Helios EN010140

Reg 20050592

Date 18/03/2025

The Battery Energy Storage System (BESS) plus the 132Kv Sub Station

Environmental Statement Figure 11.4: Noise Contour Map Daytime

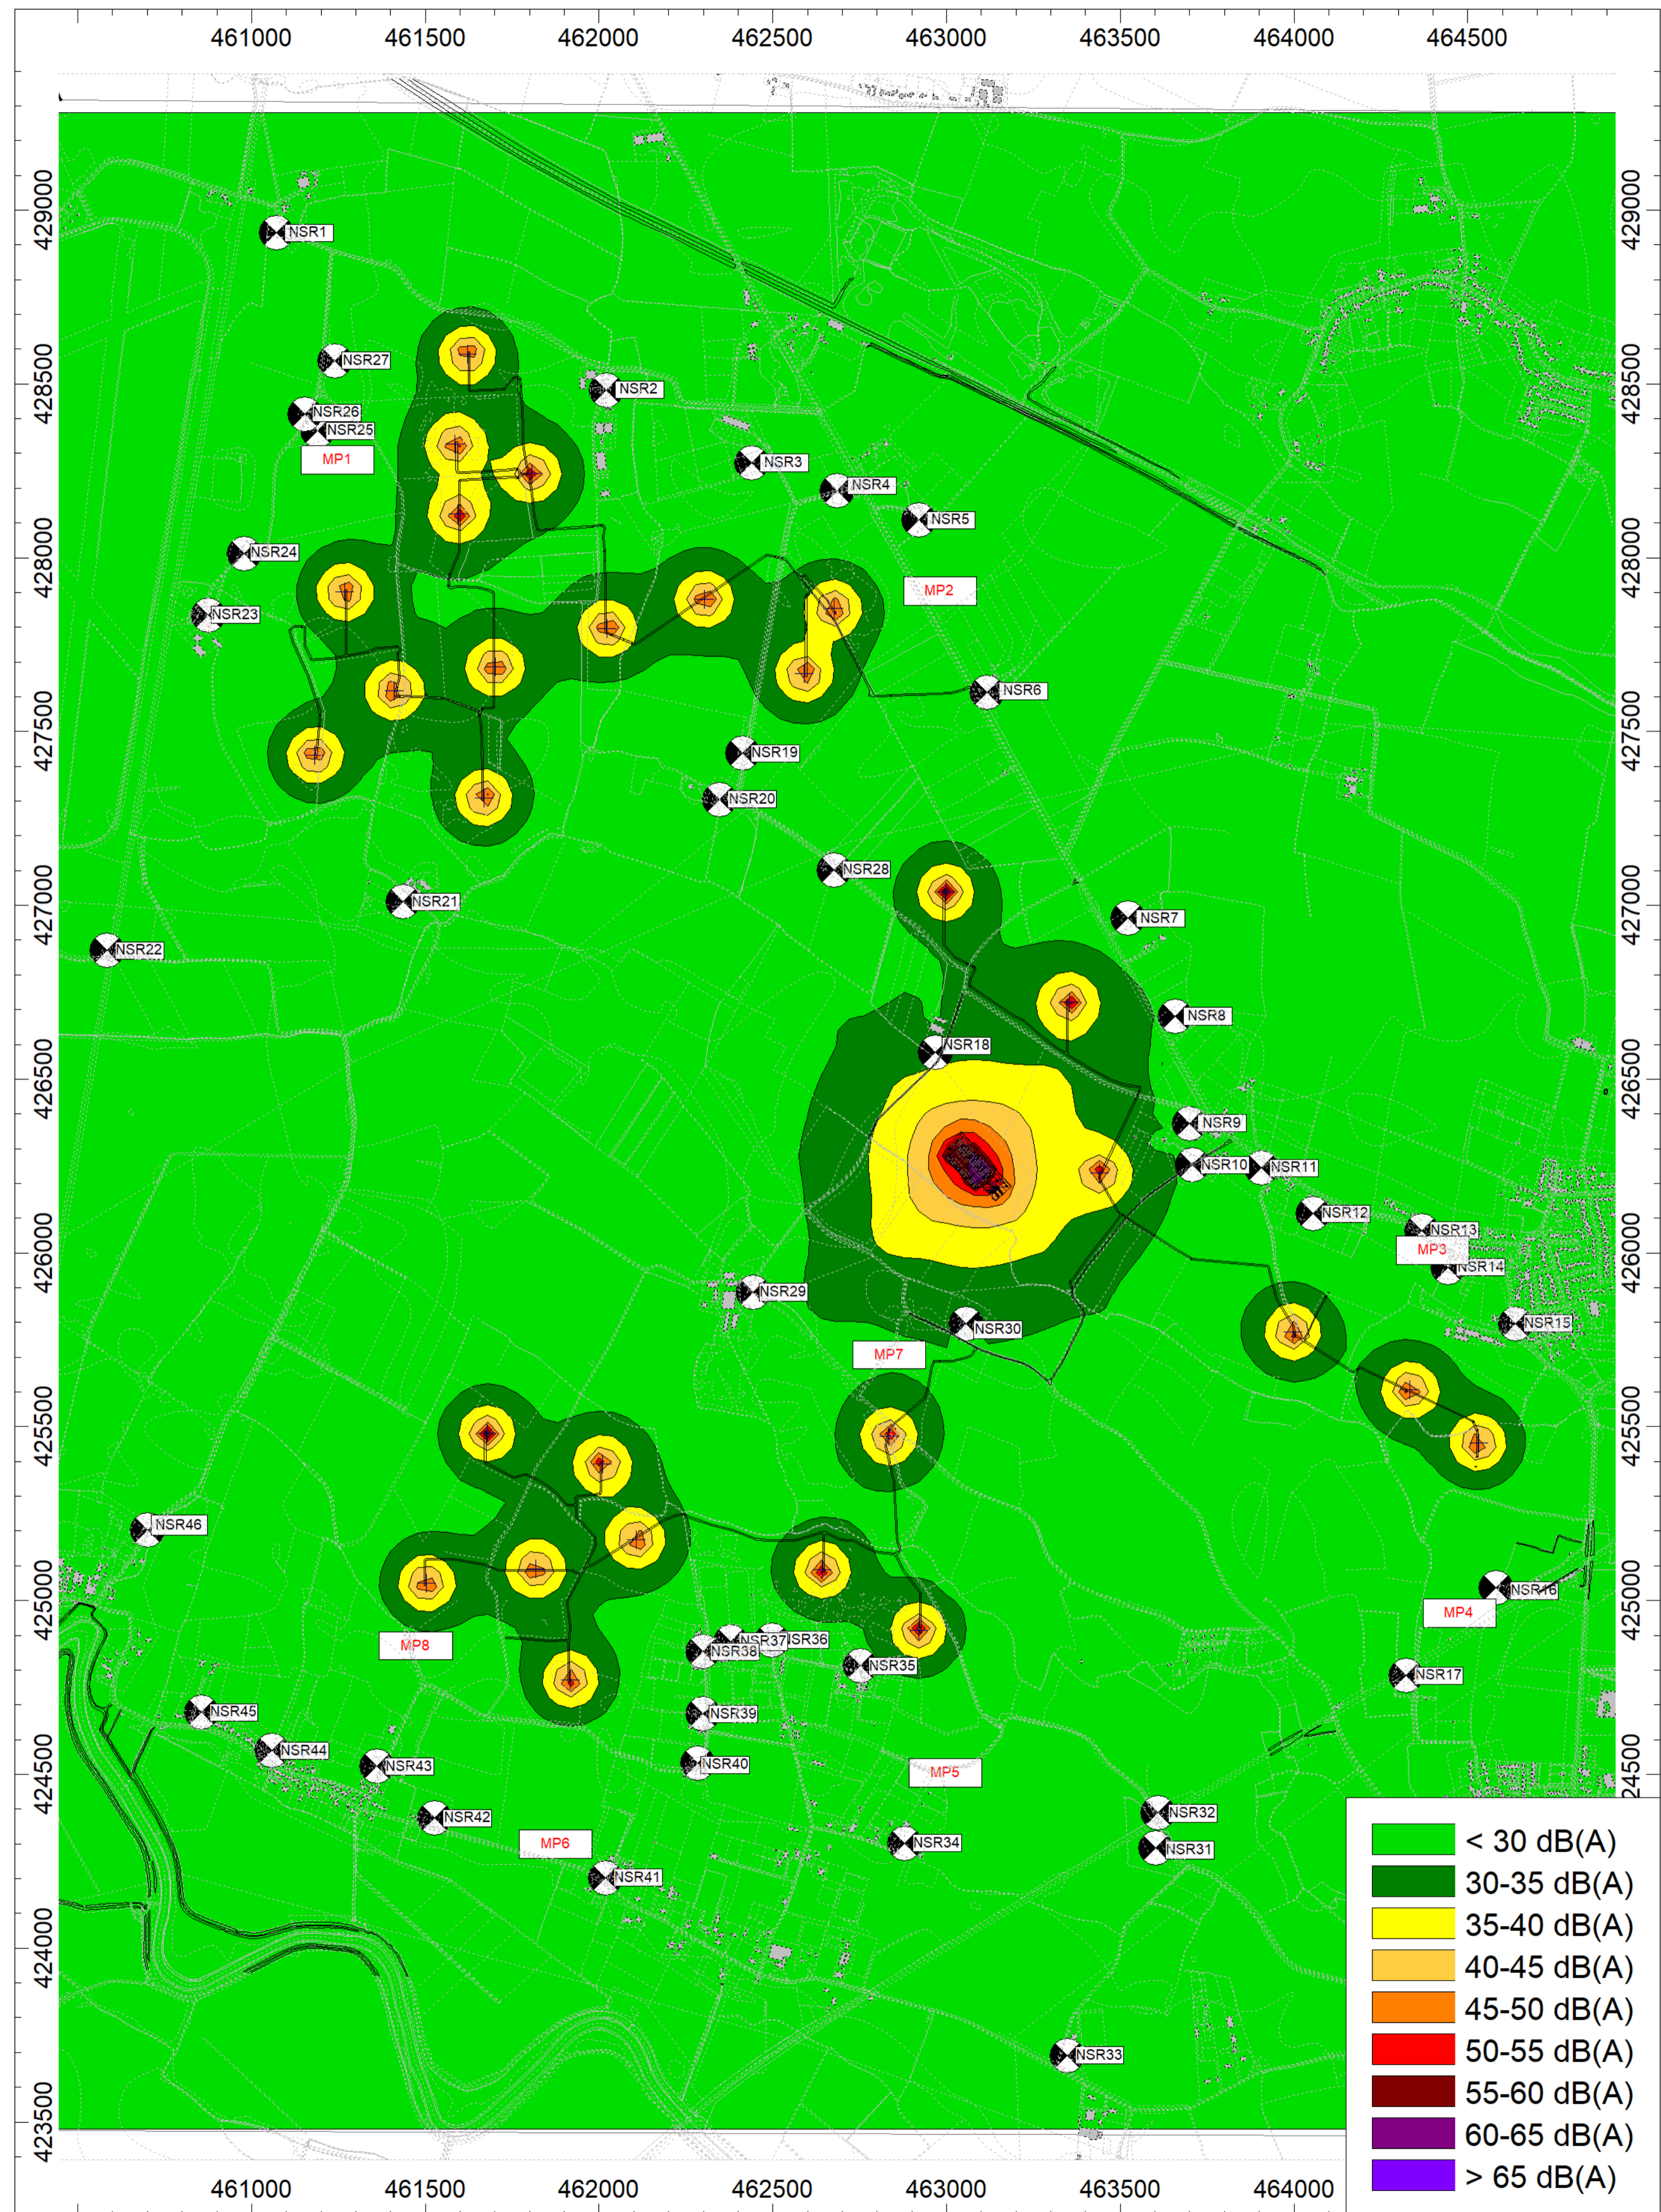
With Reference to Environmental statement Figure 11.4

(The map I have supplied number 7), has a symbol Z? which I have added. Whatever it/they are. (counted 28) They have the capability of emitting 45-50 dB of noise. The Z? in question is ALMOST AT THE BOTTOM OF MY GARDEN.

Due to the poorly detailed map, I
could not get a Fix position to measure
approx., how close it is.

1.a What are these?

Also With Reference to Environmental statement Figure 11.4

On the poorly detailed Map Fig 11.4 – Noise Contour Map Daytime, (my ID Map 7). I would like some independent assurance, that *as if by some miracle*, we are in the < 30 dB zone.

## **Environmental Statement Figure 3.7: BESS Battery Container Elevations**

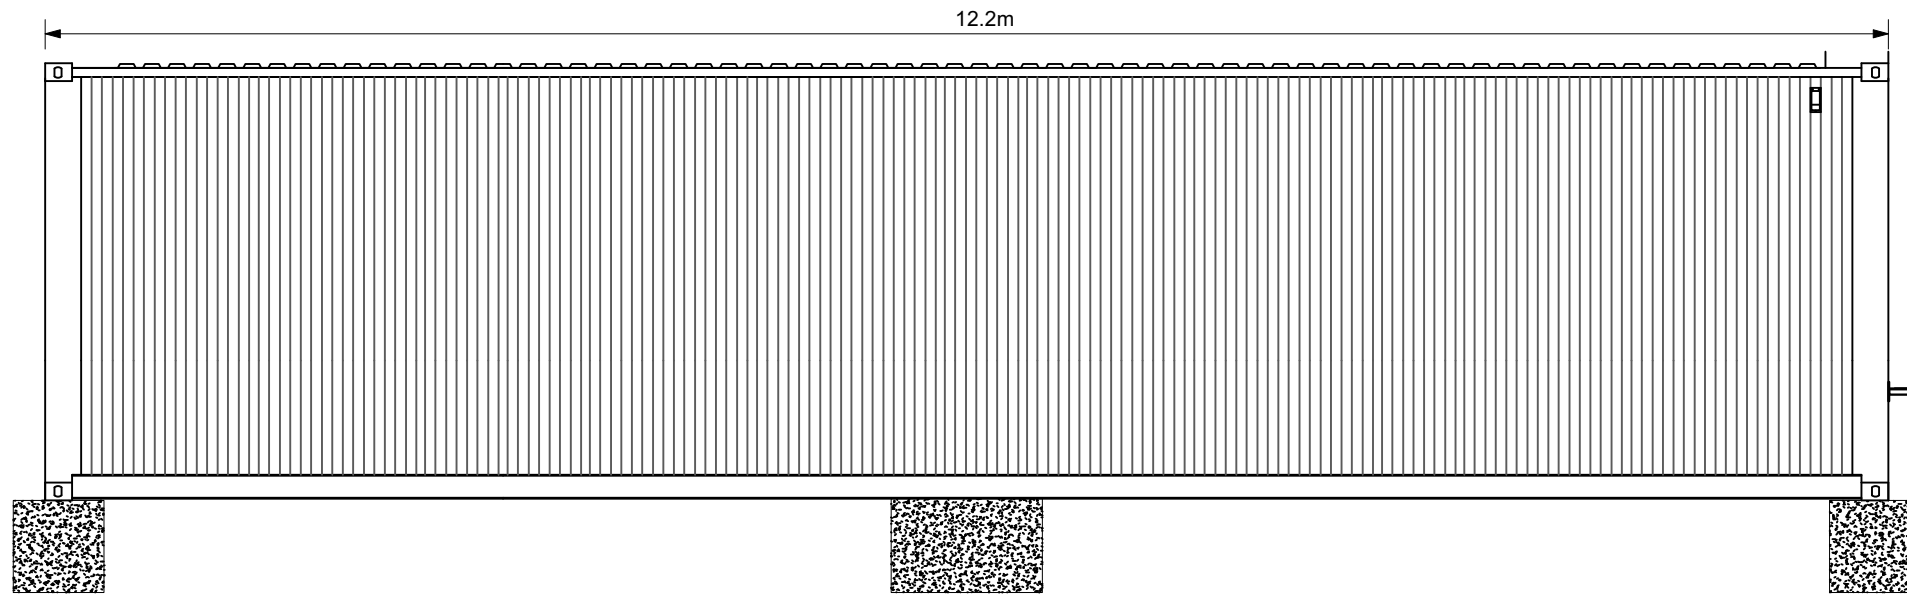
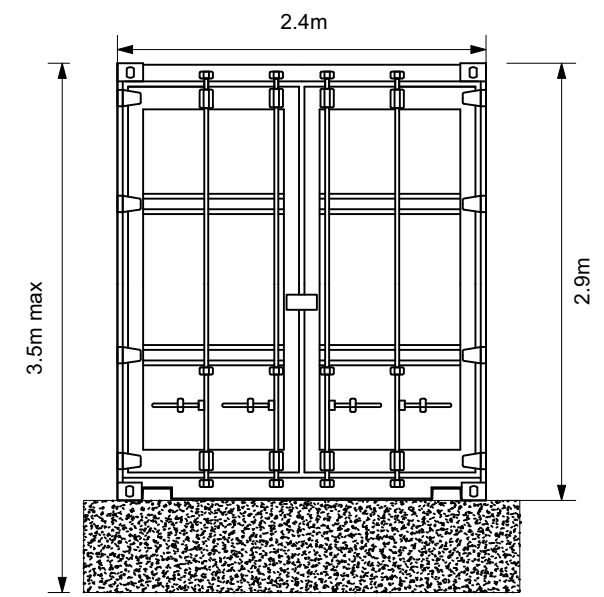
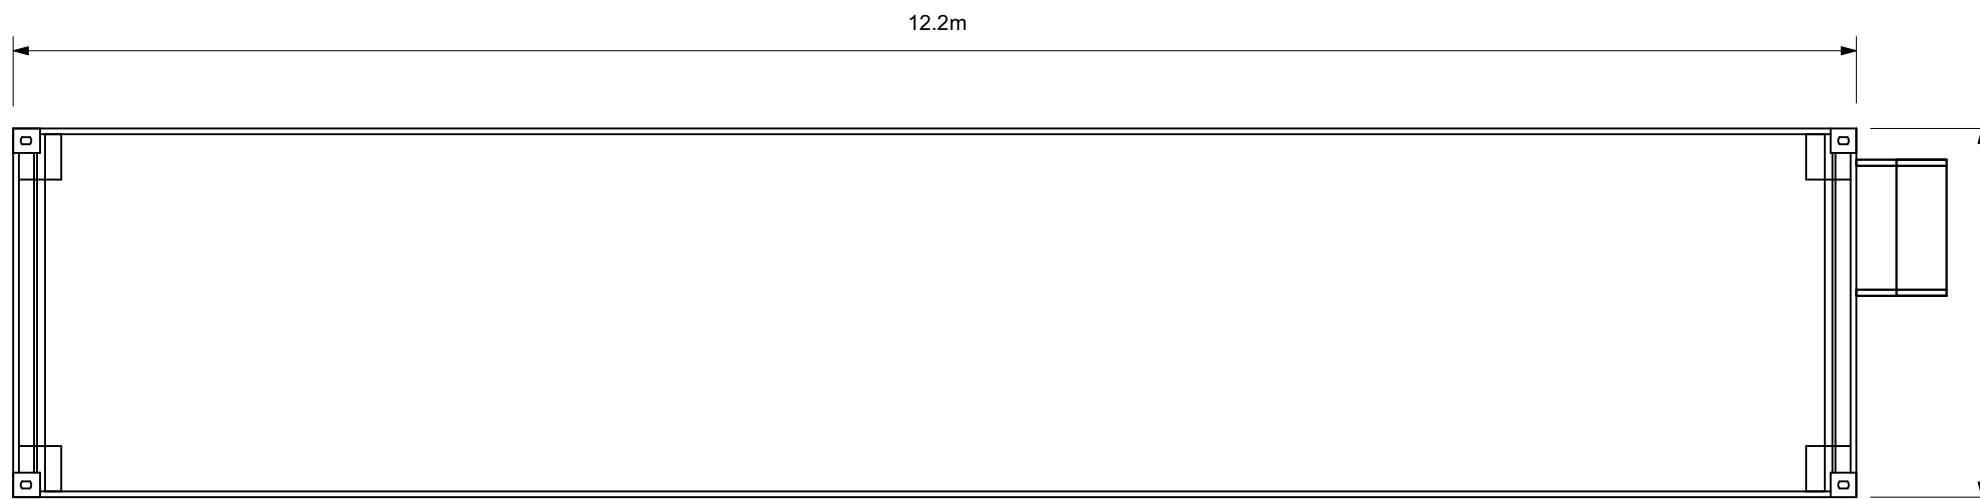
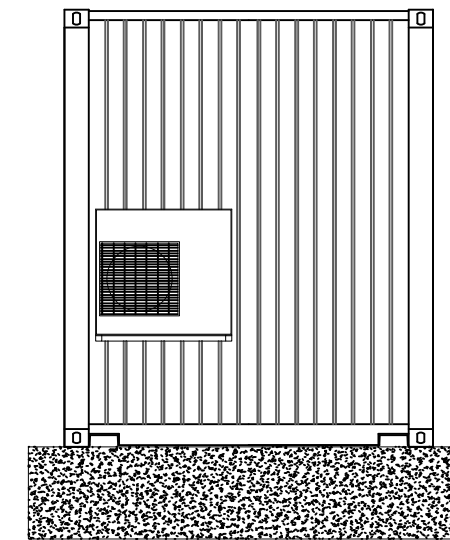
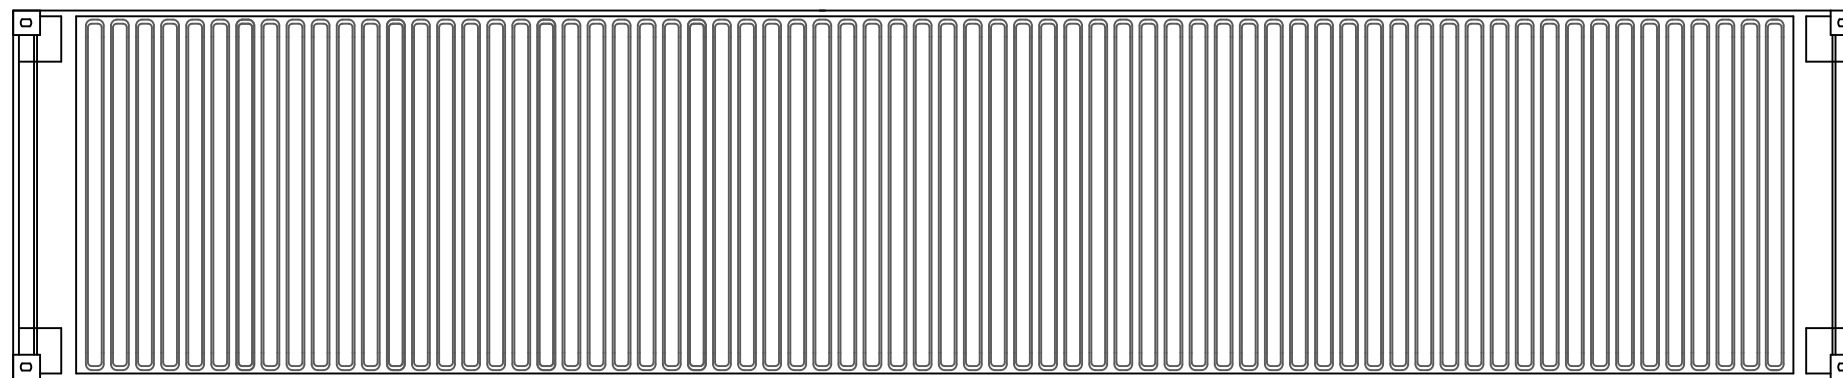
4. It does not say how many?

- **Battery containers** of up to 12.2m in length x 2.4m in width x 3.5m in height, including concrete supports 600mm in height (refer to **Figure 3.7 BESS Battery Container Elevations [EN010140/APP/6.2.3.7]**); **HOW MANY?**
